**Our Ref: WA/57/12/
Your Ref:**

Application for Planning Permission for Works or Extension to a Dwelling

Development Single storey side (south west) extension

Location Folie House Wandleys Lane Fontwell

SITE PLAN 1:500

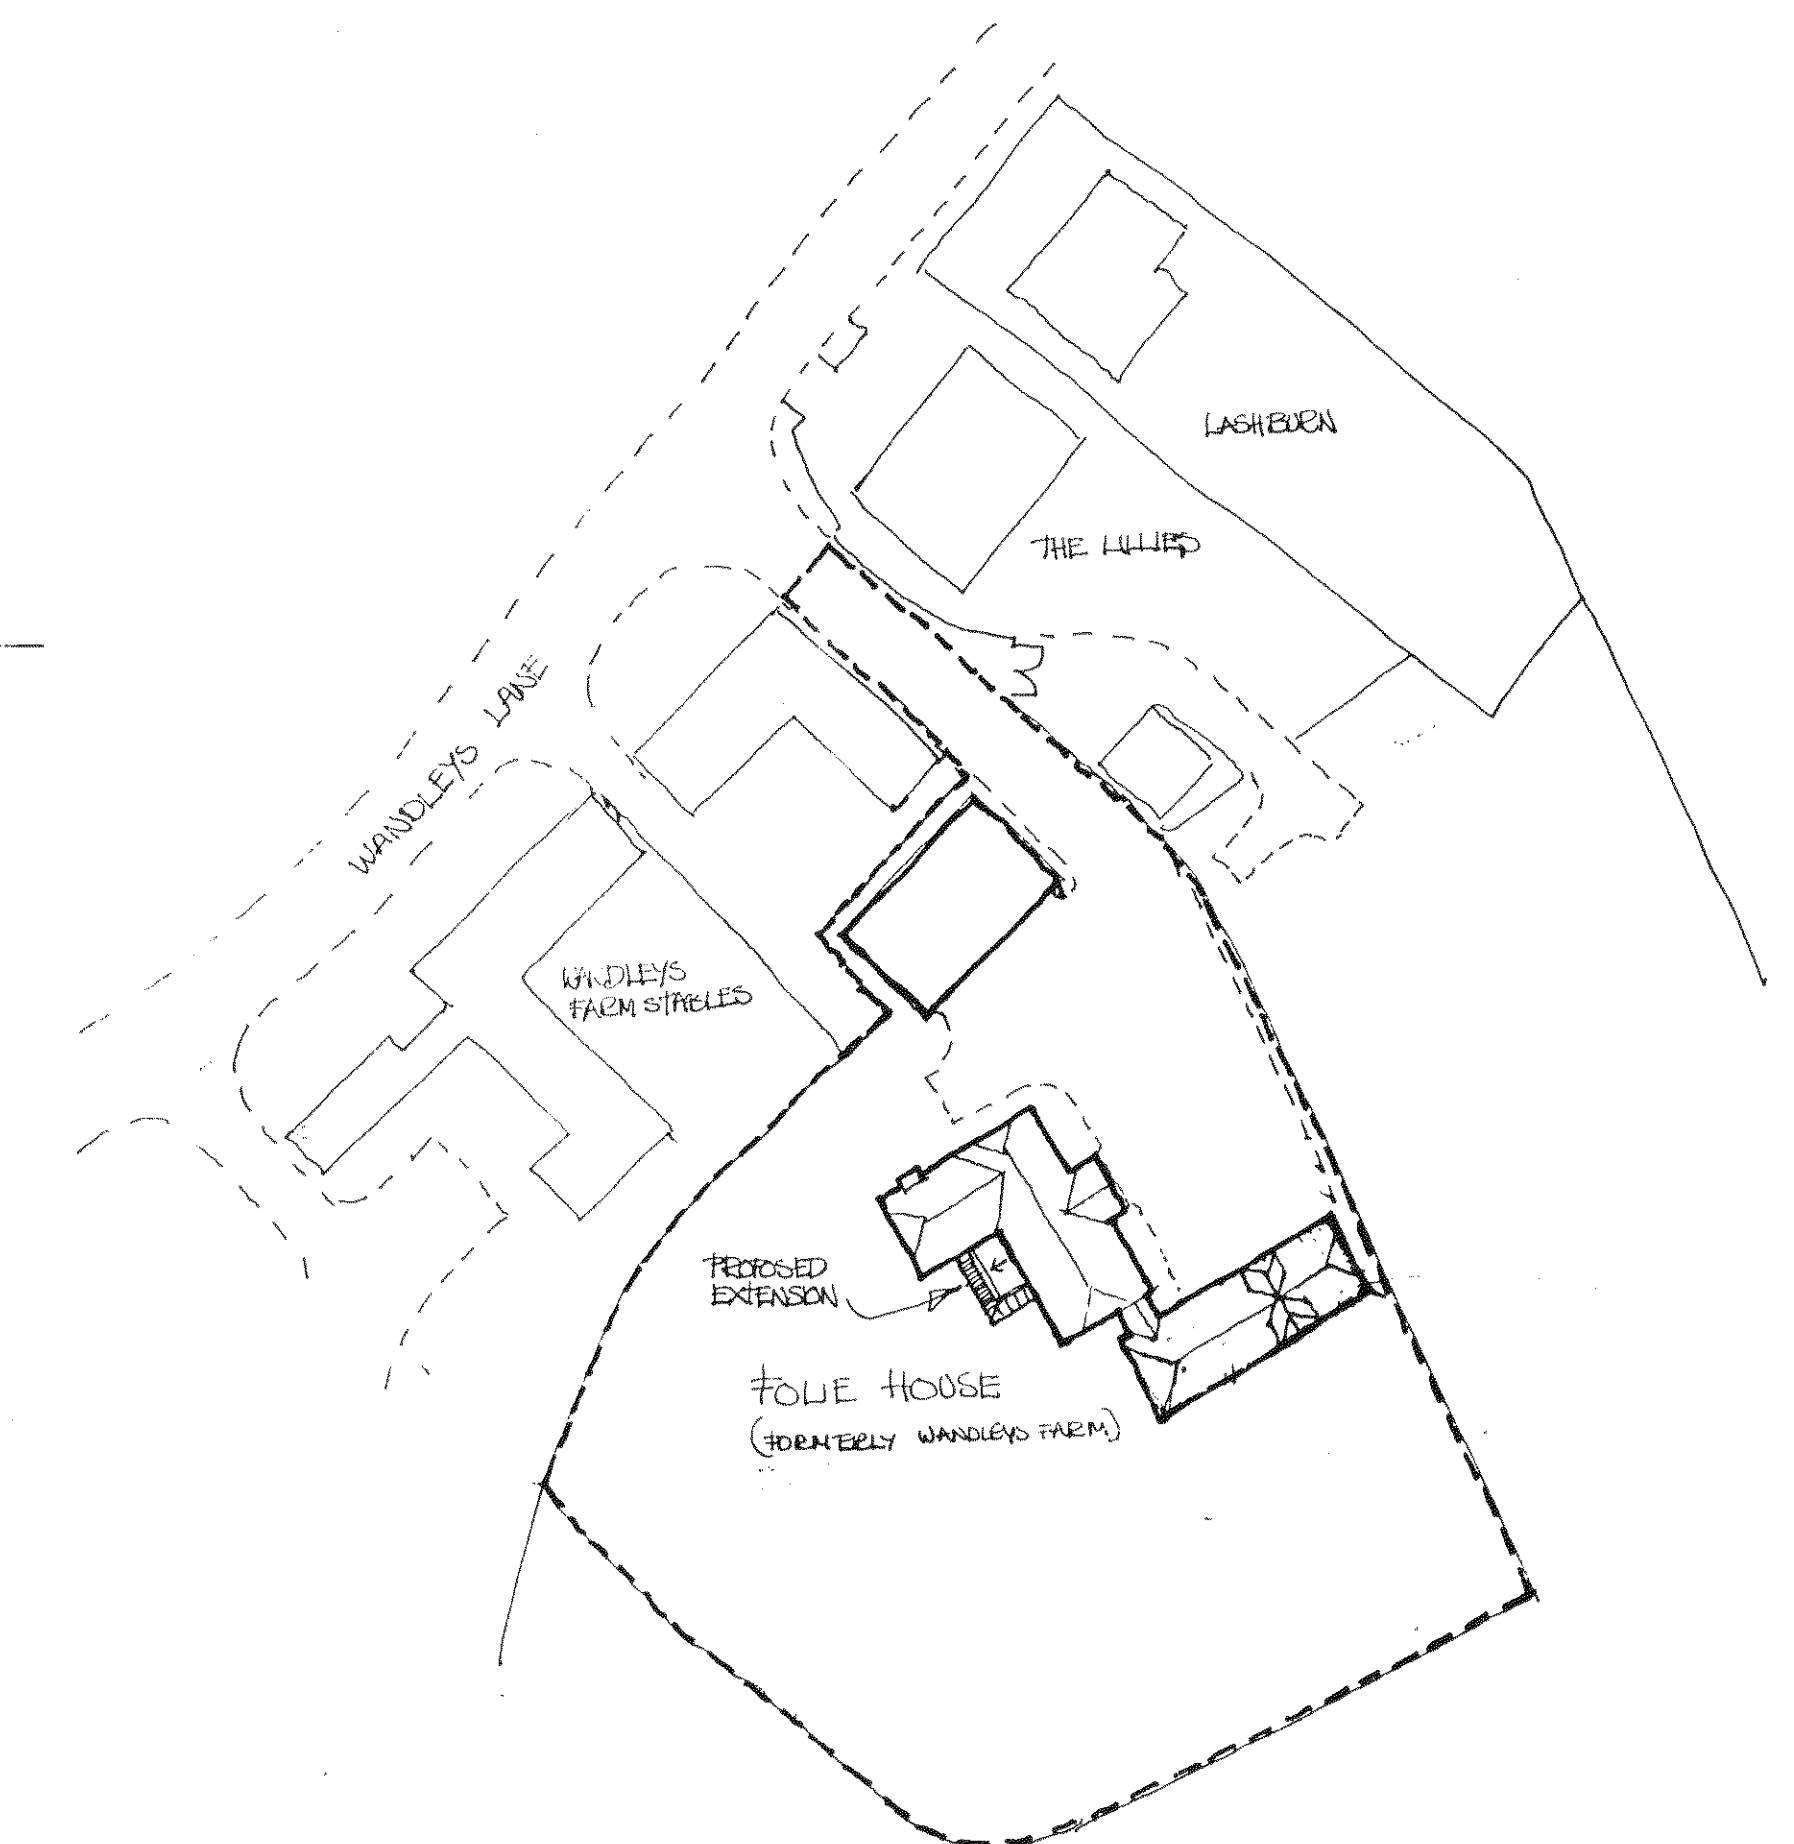
- ✓ Please submit 1 electronic or 3 paper copies of a revised block/site plan showing the proposed works clearly highlighted, in accordance with the guidance notes available on our website detailed below (click on National List).
- ✓ Please confirm whether the proposed extension will require any new drainage works. If so, will you be connecting to the mains sewer.
